When we reviewed the “Moorebank Intermodal Precinct West – Stage 3 (SSD 10341), Traffic Assessment”, we were somewhat surprised with the expected performances of the intersections on Moorebank Avenue.

For this submission, Figure 4 compares the ten-year-old surveyed traffic numbers from M1CL, EIS with the Traffic Assessment flows. The Traffic Assessment flows includes the construction and "fill" traffic.

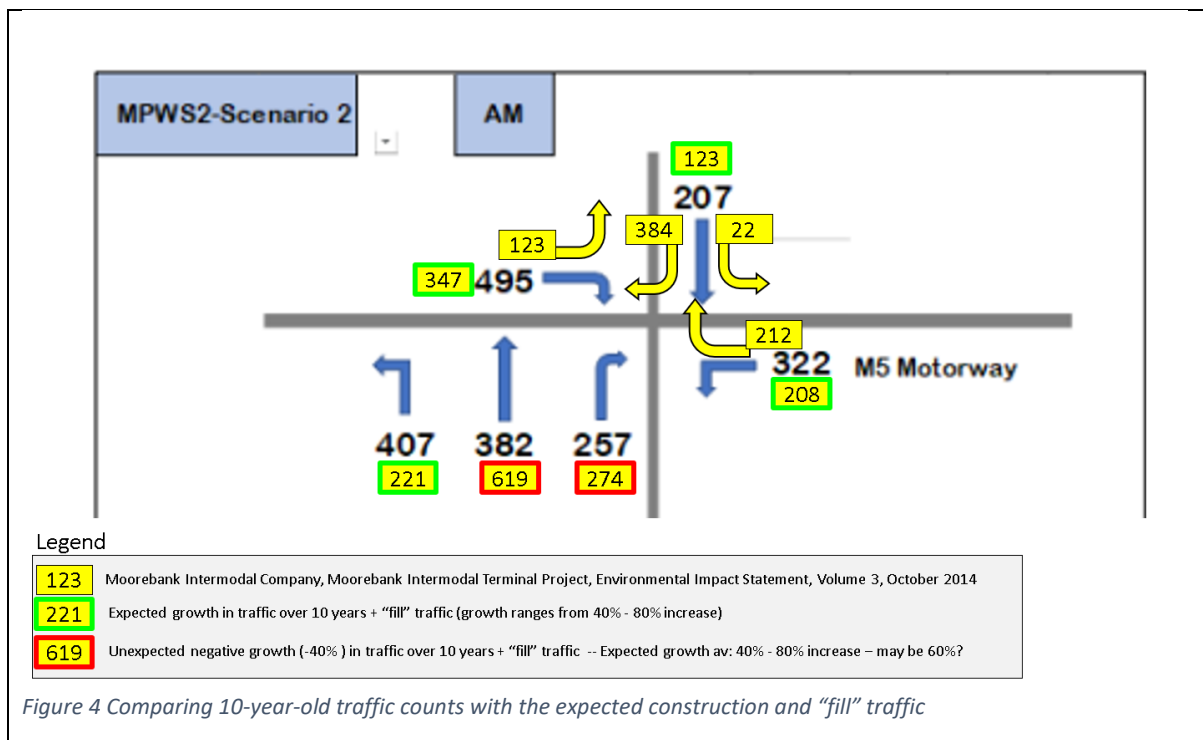
In the northbound direction, the Traffic Assessment number is 237 vehicles per hour less than the 10-year-old EIS number, and 17 vehicles per hour less for the right-hand-turning movement.

The expected northbound traffic flow represents a **negative growth of 40% over the 10-year old surveyed flows**. Intuitively, the expected number of northbound traffic would consist of two parts: (1) add 40% to bring it to the surveyed flows 10 years ago, then (2) add the expected natural growth as well as the additional construction and "fill" traffic (for the other movements, that ranges from 40% to 80%). Based on this logic, in round figures, the expected northbound traffic should be about double the quoted figure.

From the Traffic Assessment report, it is not immediately obvious why the expected flow is only 40% of the 10-year old surveyed flows.

Figure 5 shows the calculation to estimate (1) all traffic travelling southbound, and (2) traffic arriving at the next intersection. In this example, 217 vehicles disappear between two very closely spaced intersections.

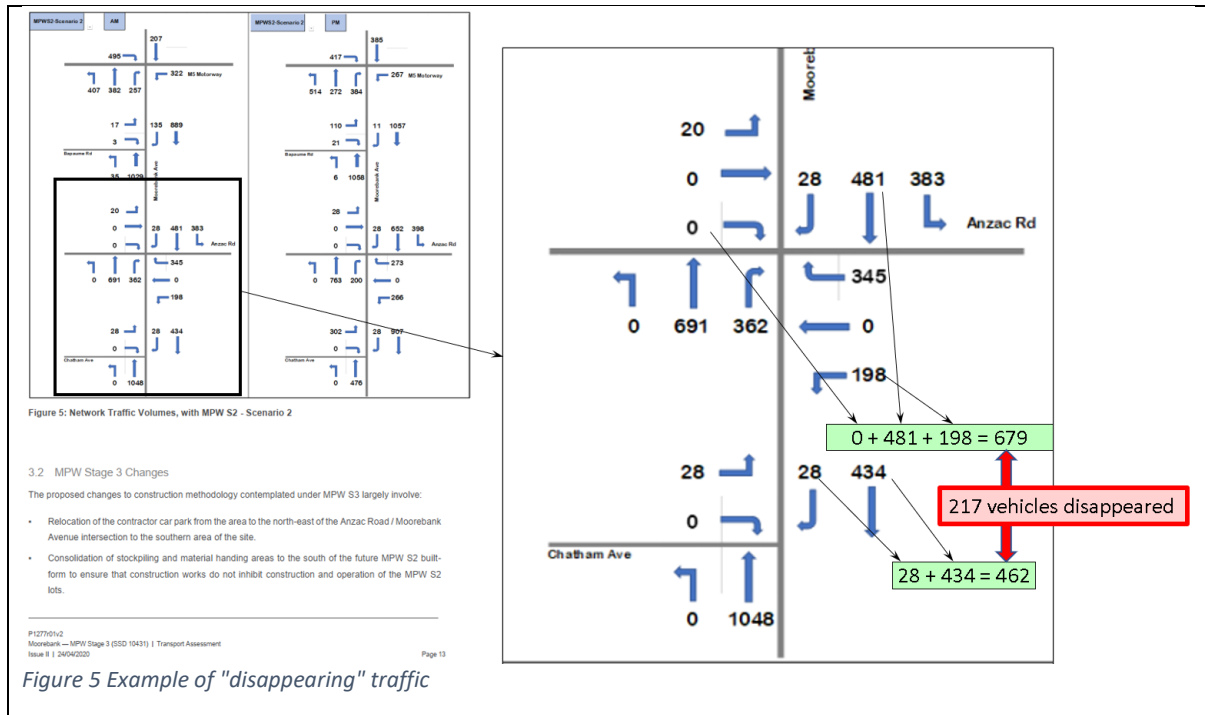
No explanation is given on the AM northbound traffic being only 40% of the 10-year old surveyed flow, nor the 217 disappearing vehicles. A simple exercise will show several other instances which do not make sense.
